PLANNING REFERENCE: PREAPP/21/00239

DEVELOPMENT PROPOSED: Proposed change of use of buildings to a residential dwelling and erection of a single storey extension.

LOCATION: The Old School Culmington Ludlow Shropshire SY8 2DF.

A	05.01.22	OS map ref. added
Revision		
Drawing Title:	The Pottery Proposed Plans	
Drawing Number:	RG-PP-01	
Scale	1:100 at A1	
Date	05.11.21	Page 9 of 12
jacklines12@hotmail.co.uk		07904436078

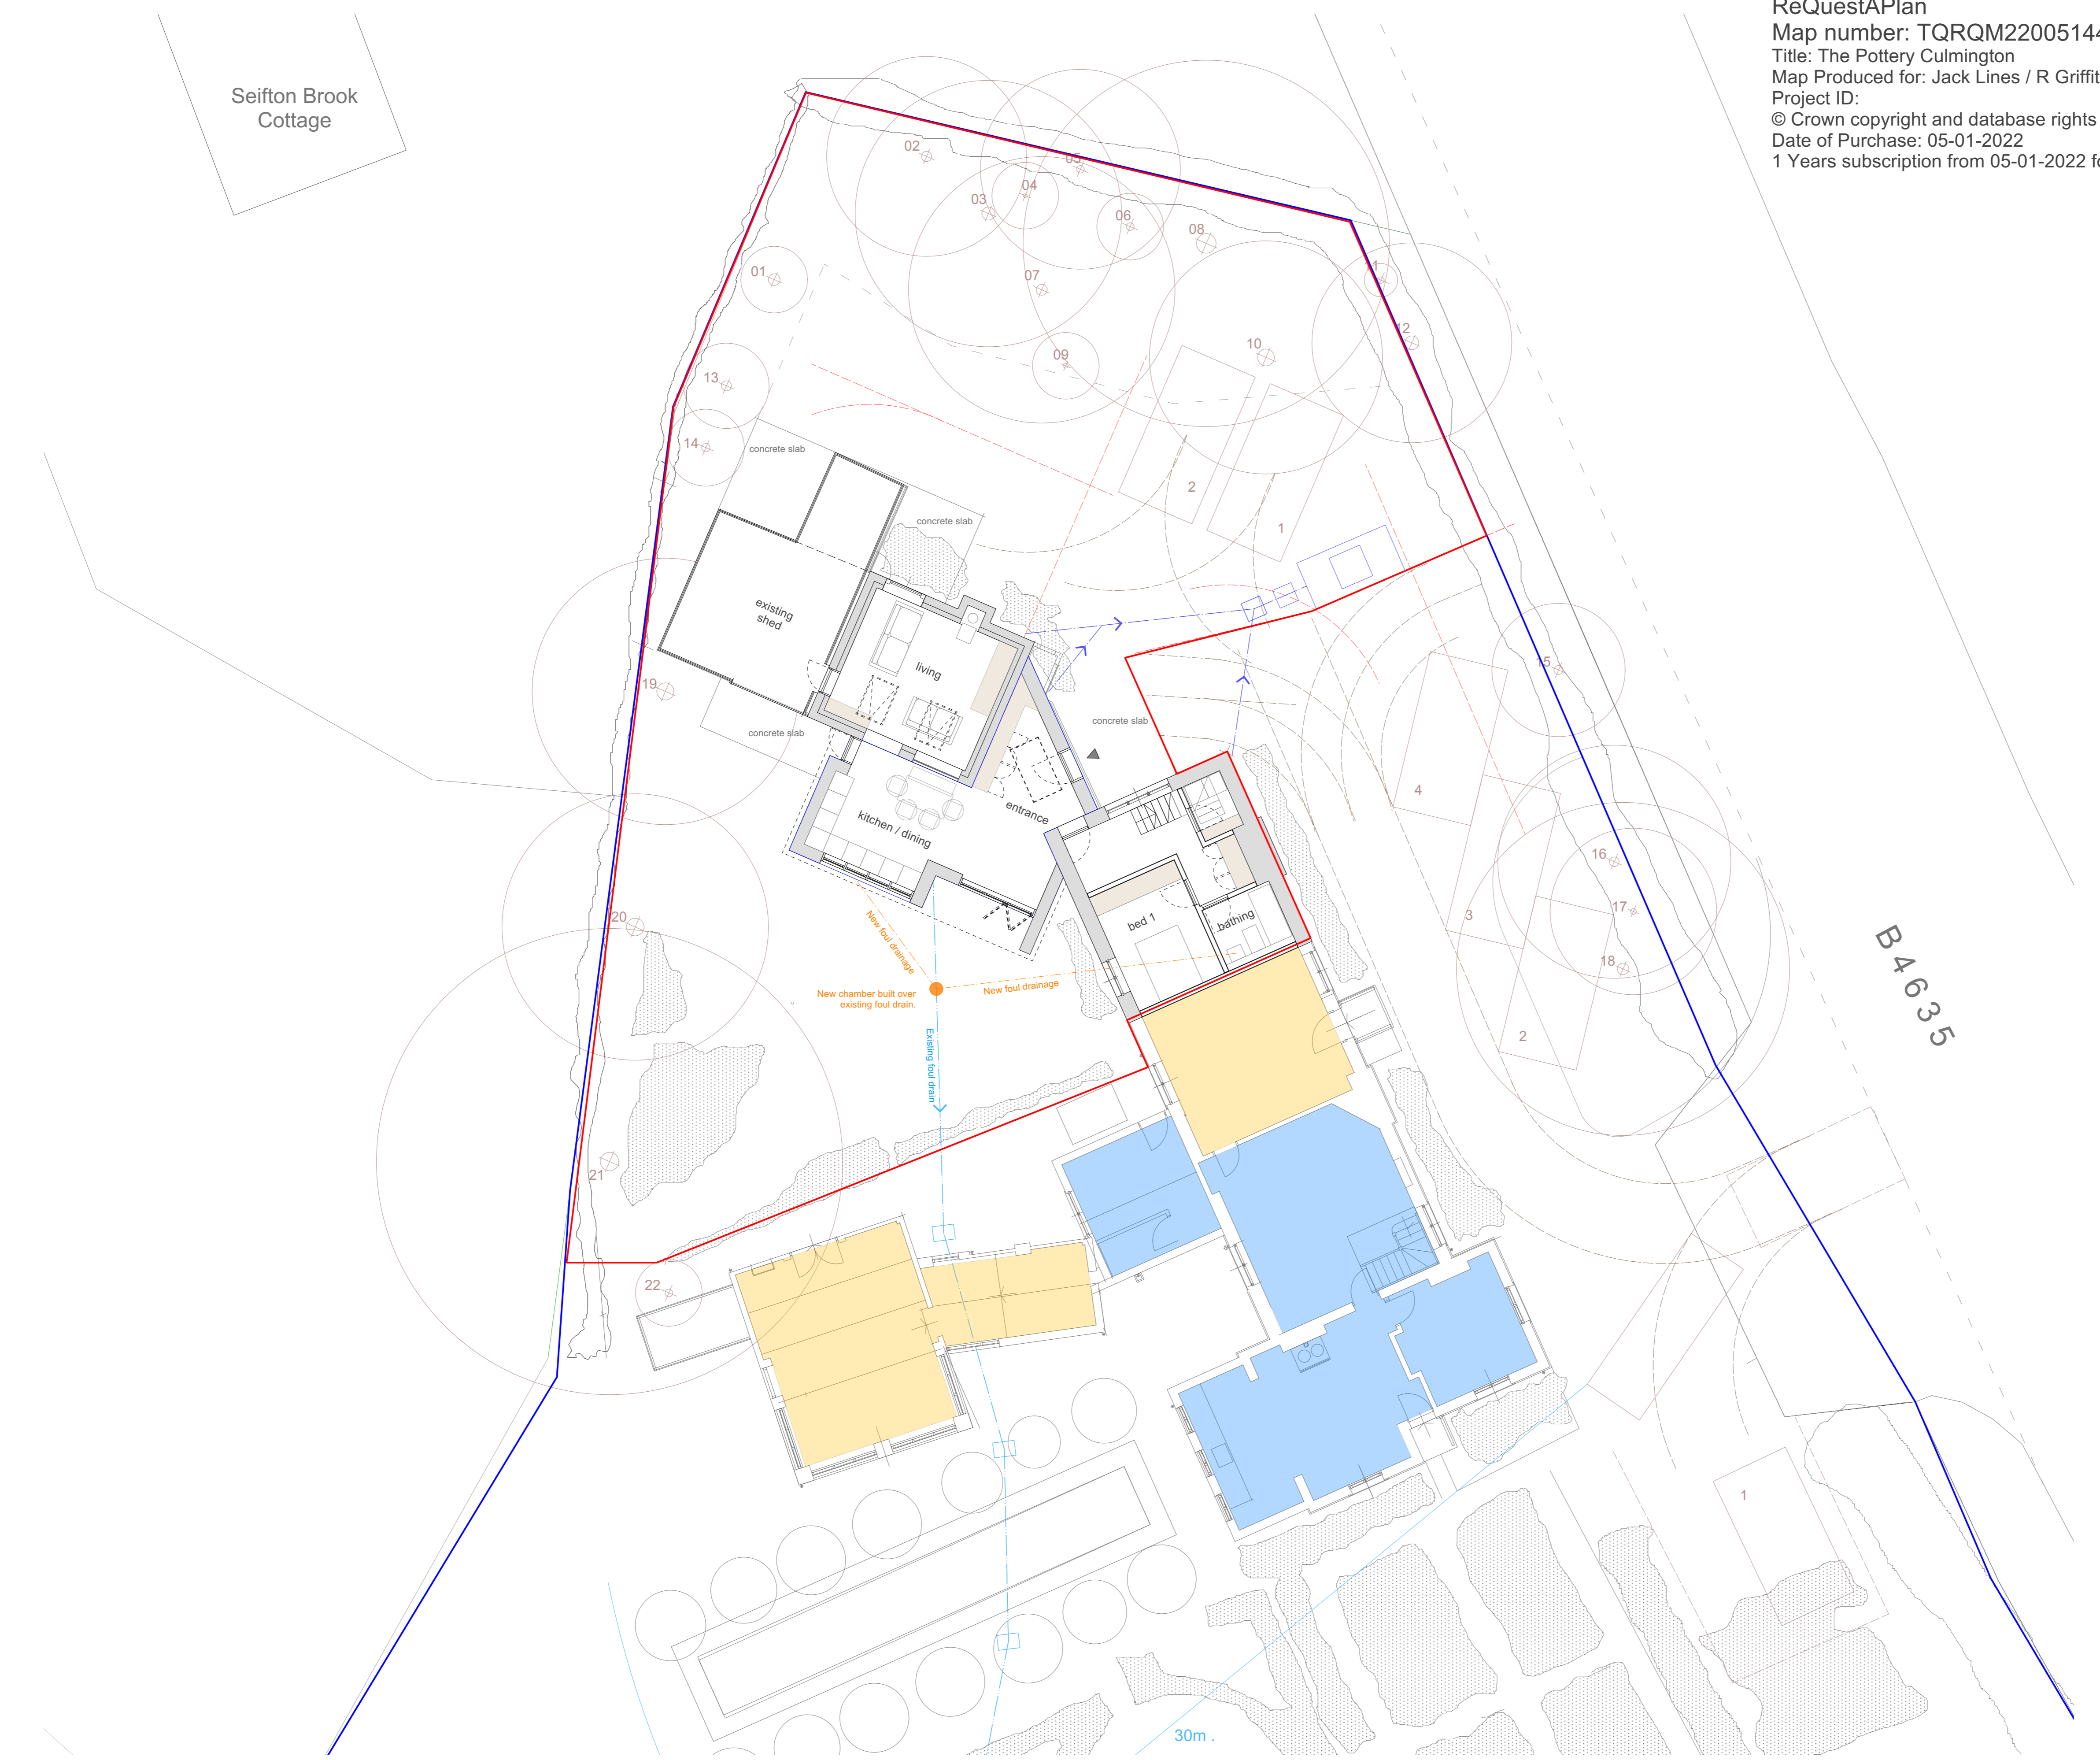
The proposed change of use application appears to introduce no significant arboricultural implications and whilst the Tree Team would seek for the provision of a tree protection plan with any full application, we do not consider trees to be a significant constraint on the development, as indicated on the provided plan RG-PP-01.
